**Moorebank Intermodal Precinct West - Stage 2, Modification 1 (SSD-7709-Mod-1)
Request for Additional Information**

ATTACHMENT 1: KEY MATTERS

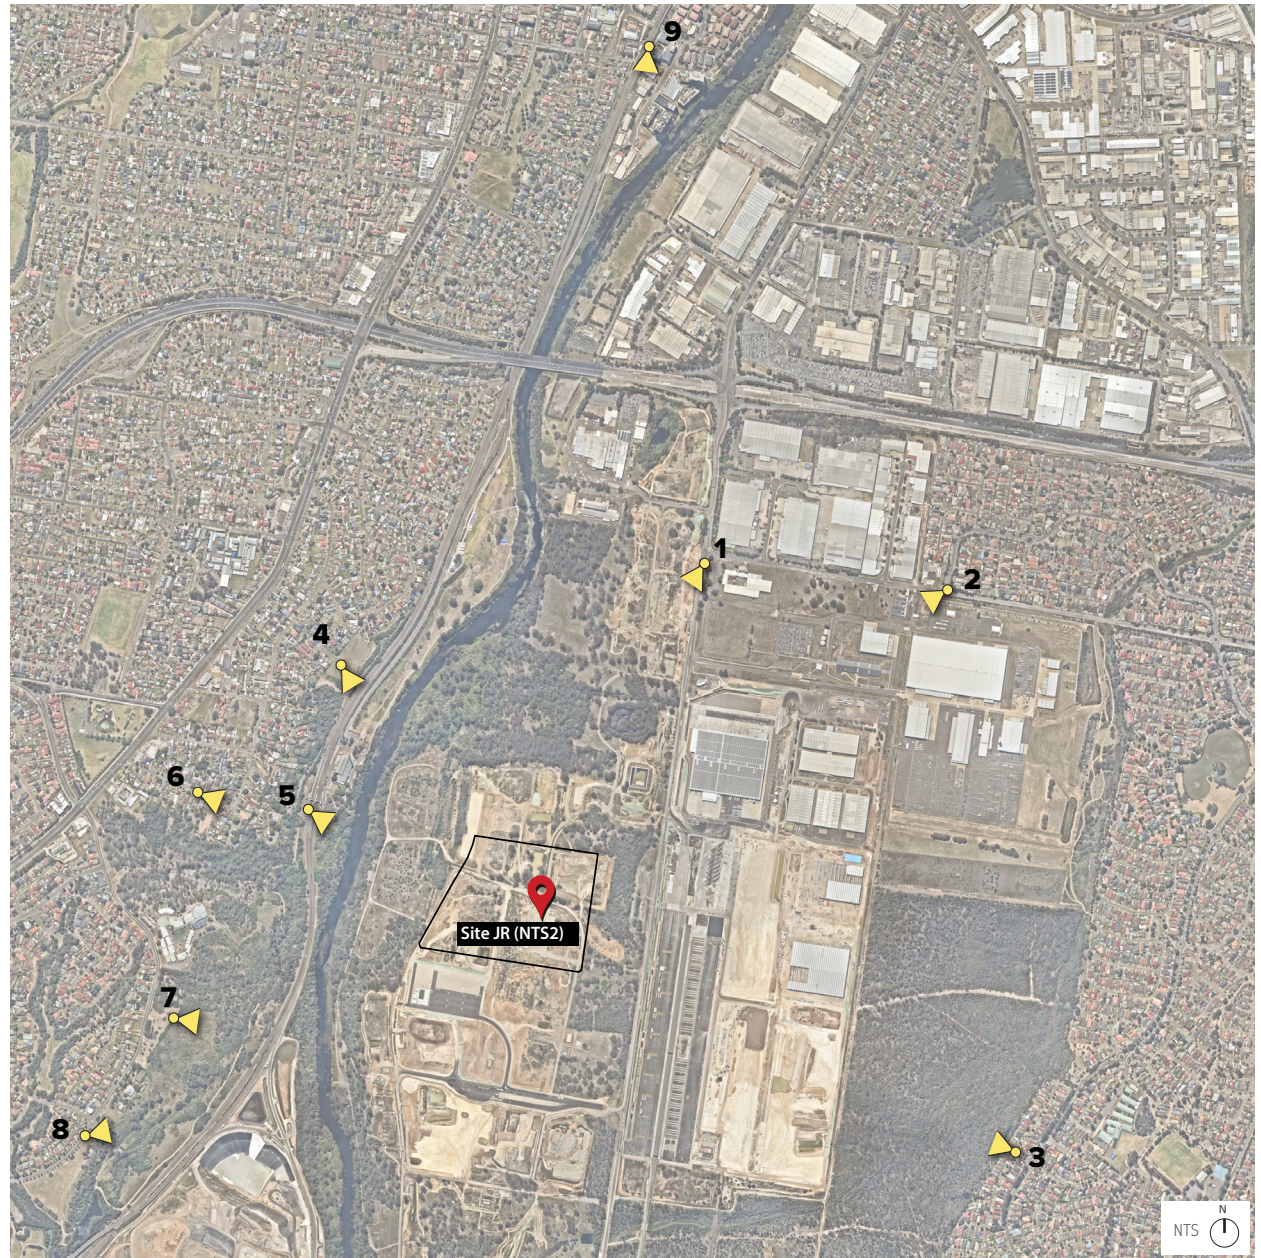
The Department notes that there is an error contained within the visual assessment reports for warehouses JN + JR dated October 2020, relating to the private view shown at View Point 9 (attributed to 7 Casula Road). Rather, the survey appears to have been taken from the mid-way point of the sloped driveway at 3 Casula Road, below the private residence which is located on elevated land higher upon the ridge. The sightline therefore does not provide an accurate representation of the visual impact of the high-bay warehousing from the elevated properties at Casula Road, many of which appear to have unobstructed views over the MPW site.

1. additional visual impact surveys, to be taken from private vantage points at the worst affected elevated residences at Casula Road (i.e. from the residence itself);
2. amendments to remove the erroneous reference to 7 Casula Road for View Point 9; and
3. ensure that the reports revisit each of the vantage points used to inform the visual impact analysis for the approved Stage 2 application.
